# SSD 7542 RPA Multi Storey Staff Car Park

## Response to Submissions – October 2016

**NORTHERN FACADE CLIMBERS DETAIL PLAN**  
SCALE 1:50 @ A3

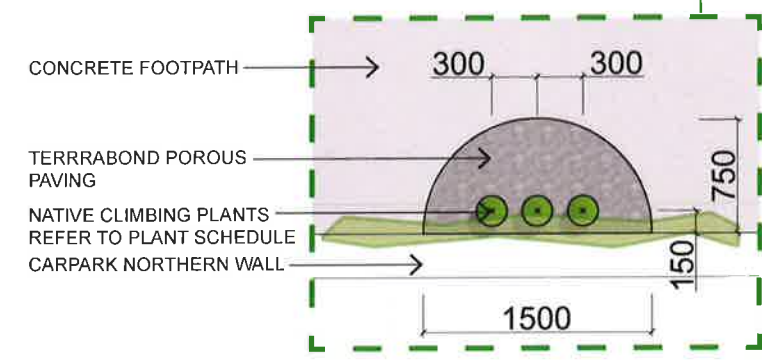
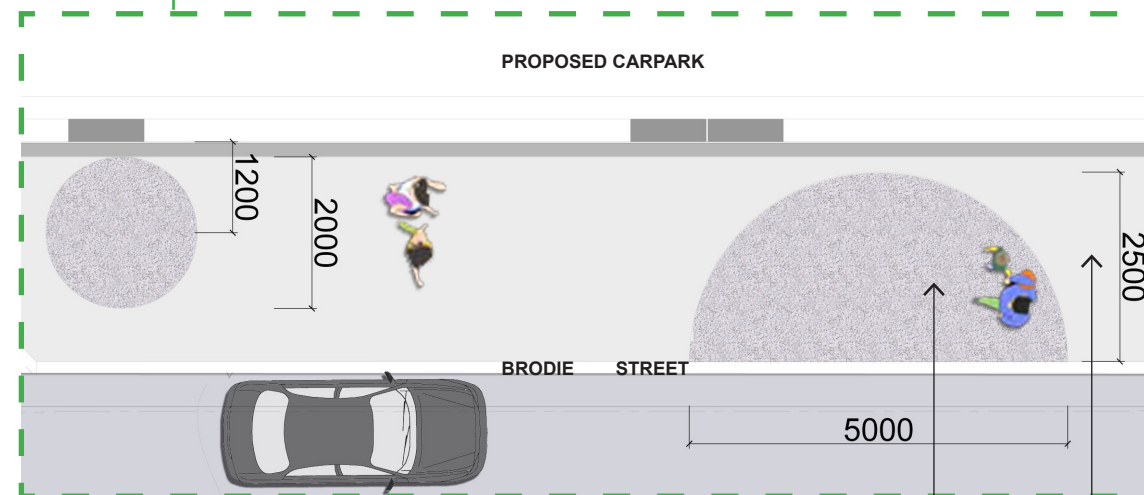
<p><b>Footway Planting</b> The landscape plan indicates a design intent to plant climbers along the facade of the building. This requires changing portions of the public footway to terrabond to allow water penetration to the root area. Due to the increased foot traffic at street level it is likely that the terrabond would result in increased maintenance needs. For this reason and the increased trip hazard risk to the public the design cannot be supported. It is noted that owner's consent from the City, as owner of the Lucas Street footpath, has not been obtained. It is recommended that the applicant amend the plans to either delete the planting, or alter the building facade to accommodate the proposed planting wholly within the property boundary.</p>	<p>Proposed Planting zone will be maintained within the boundary including any terrabond if utilised to ensure that the footpath maintains its maximum width between the existing kerb line and the boundary.</p>

1 LUCAS ST FACADE SECTION A
1:40

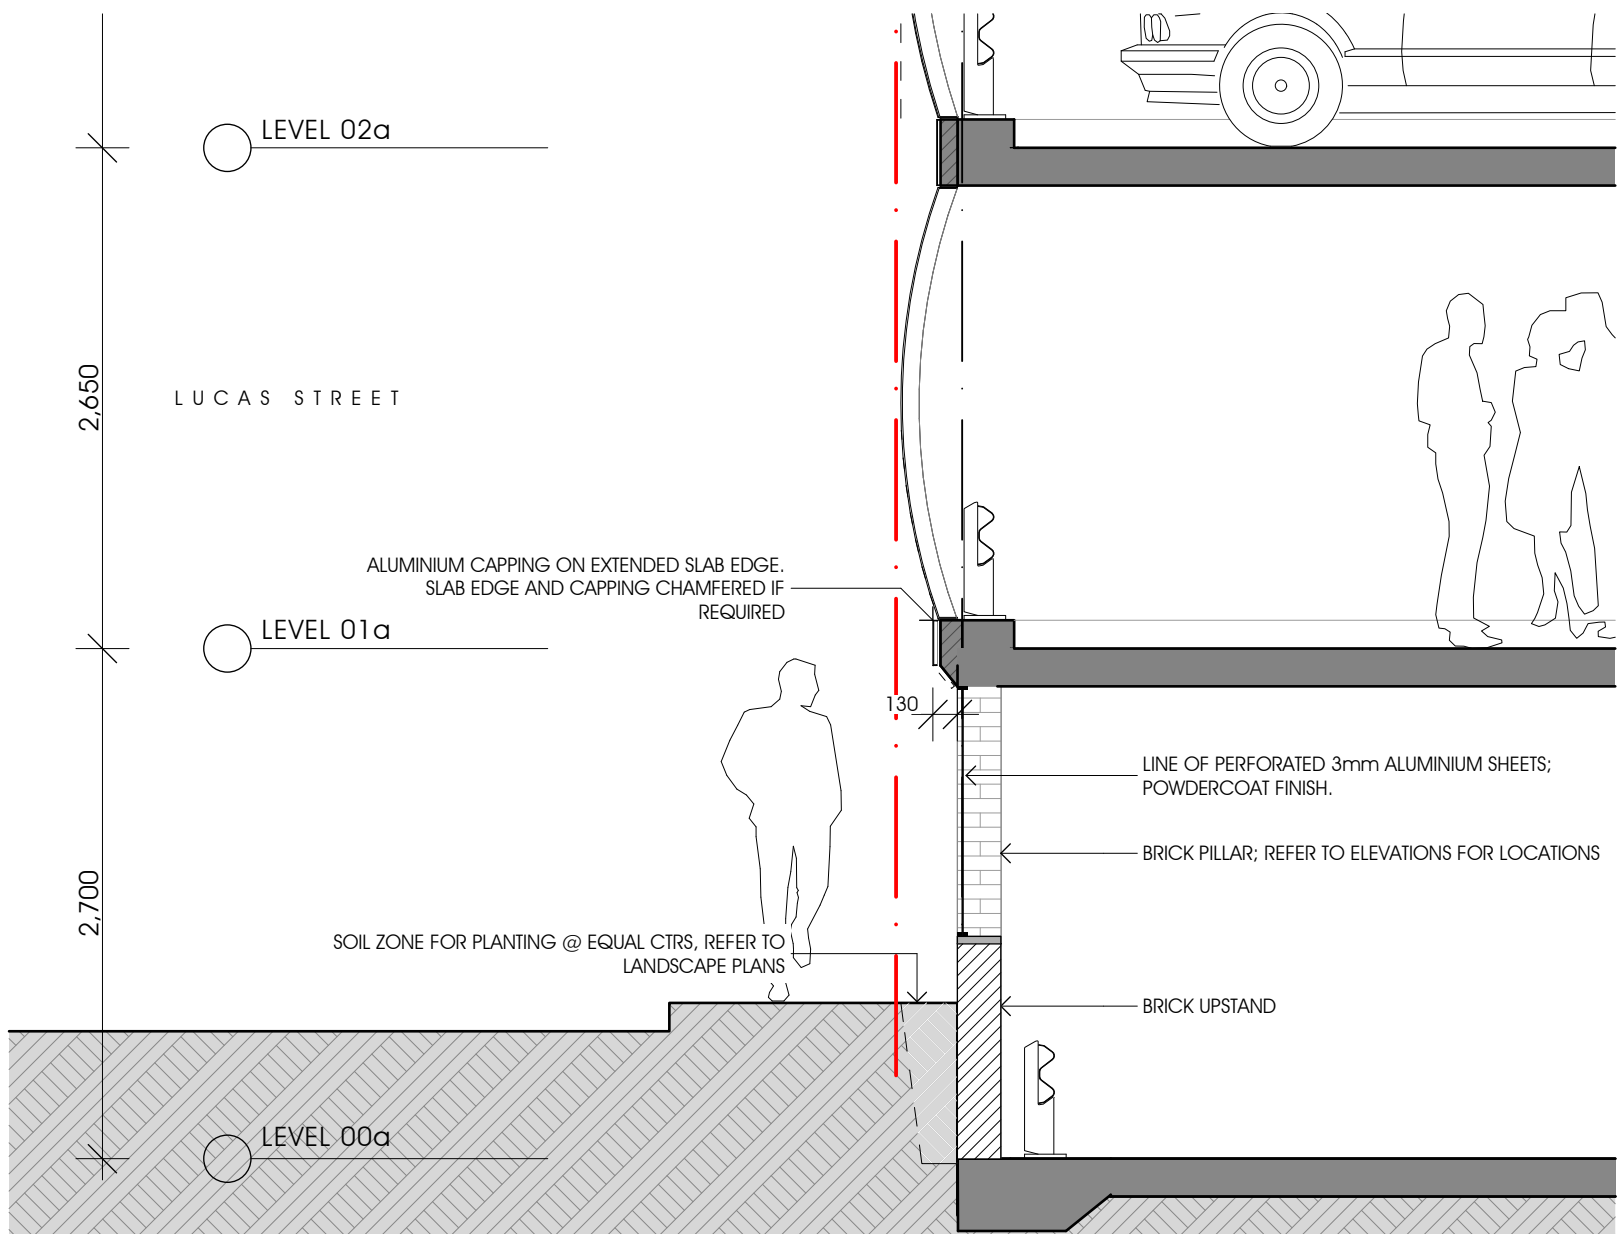
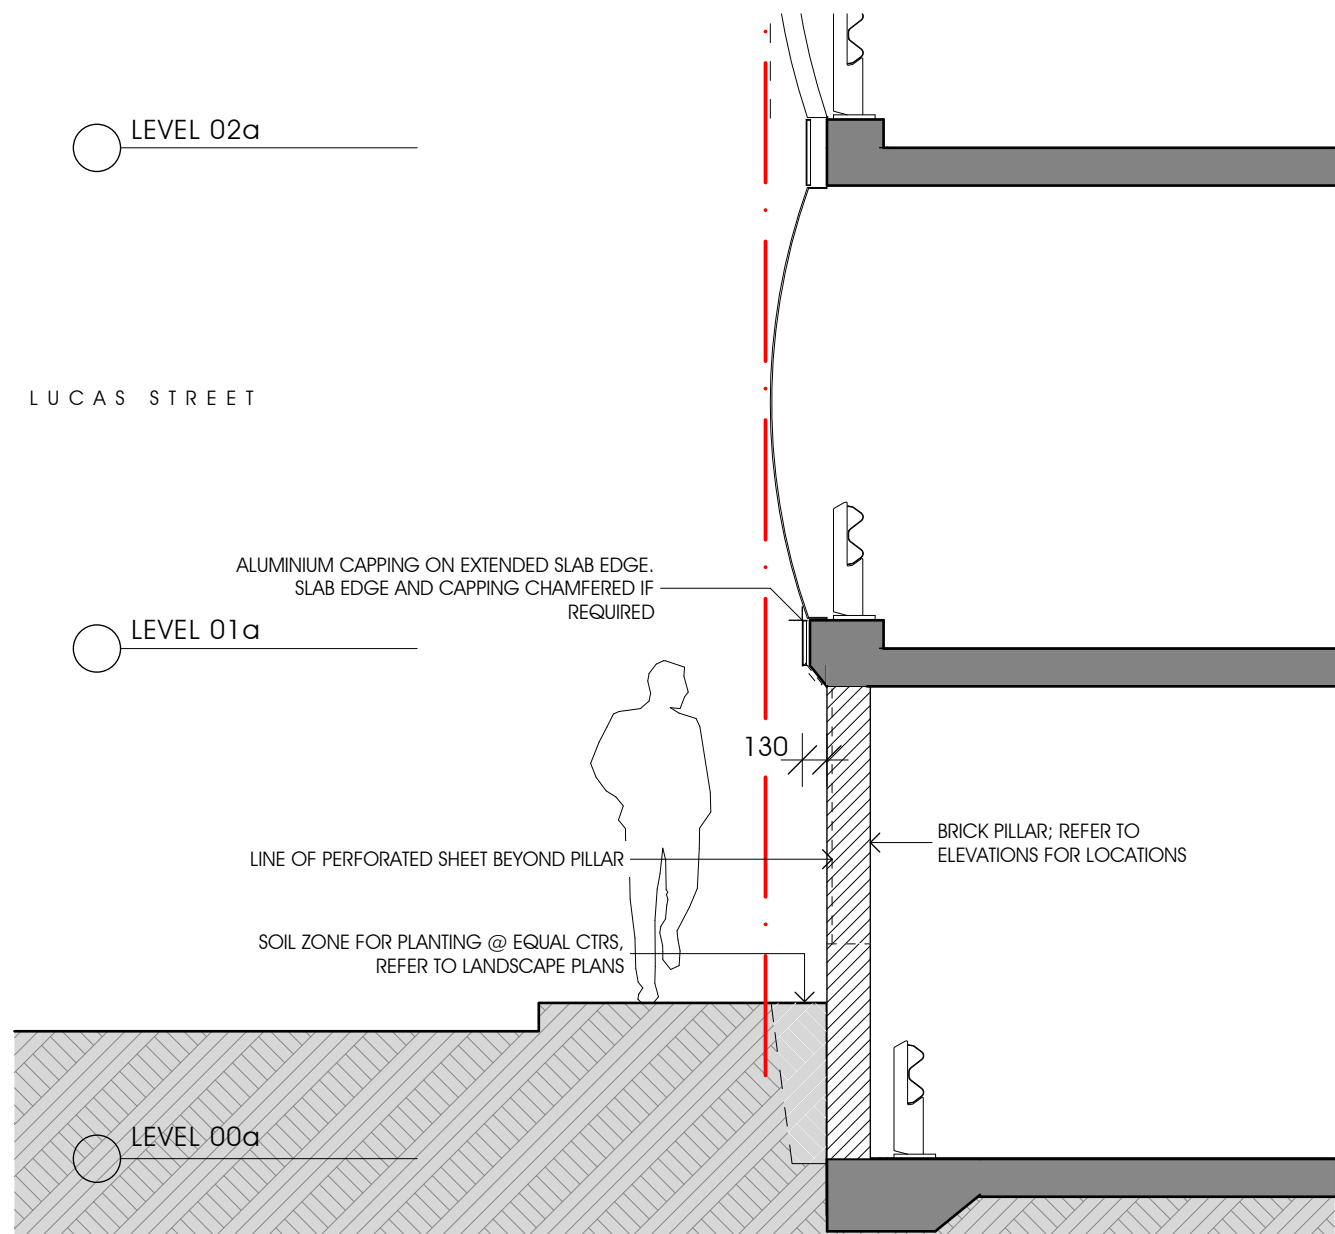
<p><b>Overhangs</b></p> <p>The facade design includes curved metal screens which overhang the building footprint at ground level. This is acceptable, however the Lucas Street Section on drawing DA-0206 shows that the overhang starts at a height of 1.65m over the footpath level at the point of the section. This is not acceptable, and a re-design is required to ensure that the building alignment is clear of obstructions for at least 2.5- 3m above the level of the footpath.</p>	<p>The overhang is approximately 130mm in depth, is rounded in the corner, and is generally obstructed by the planter bed (refer to the section at <b>Attachment D</b>). Accordingly, it is not deemed to be a safety risk.</p>
<p><b>Light Spill</b></p> <p>The potential for negative impacts of light spill is not properly addressed in the application. The detail elevation on drawing DA-0204 shows that the perforations may be in the order of 75-100mm in size, despite being labelled as 'small'. This will allow the building to 'glow' at night time, as the scale of perforations does not provide any barrier to light spill.</p> <p>It is recommended that additional mitigation measures be considered to ensure that light spill does not negatively impact the surrounding locality. Measures should also be implemented to prevent headlight beams shining directly into habitable rooms in the Queen Mary Building (QMB).</p>	<p>The potential impacts of light spill from the proposed development has been carefully considered during its detailed design:</p> <ul style="list-style-type: none"> <li>▪ The perforations in the façade screens have a diameter of 10mm (rather than 75-100mm) and as such serve to limit the extent of light spill in the surrounding area.</li> <li>▪ No parking bays have been located immediately adjacent or perpendicular to the southern façade.</li> <li>▪ The major bulk of the building has been pulled back from the western boundary to reduce the impact on the residents of Church St. The entry and exit ramps have a solid 1200mm high barriers to reduce light spill from entering/existing cars.</li> <li>▪ Solid panels are to be fixed to the crash barriers within the car park to further block out direct light.</li> </ul>
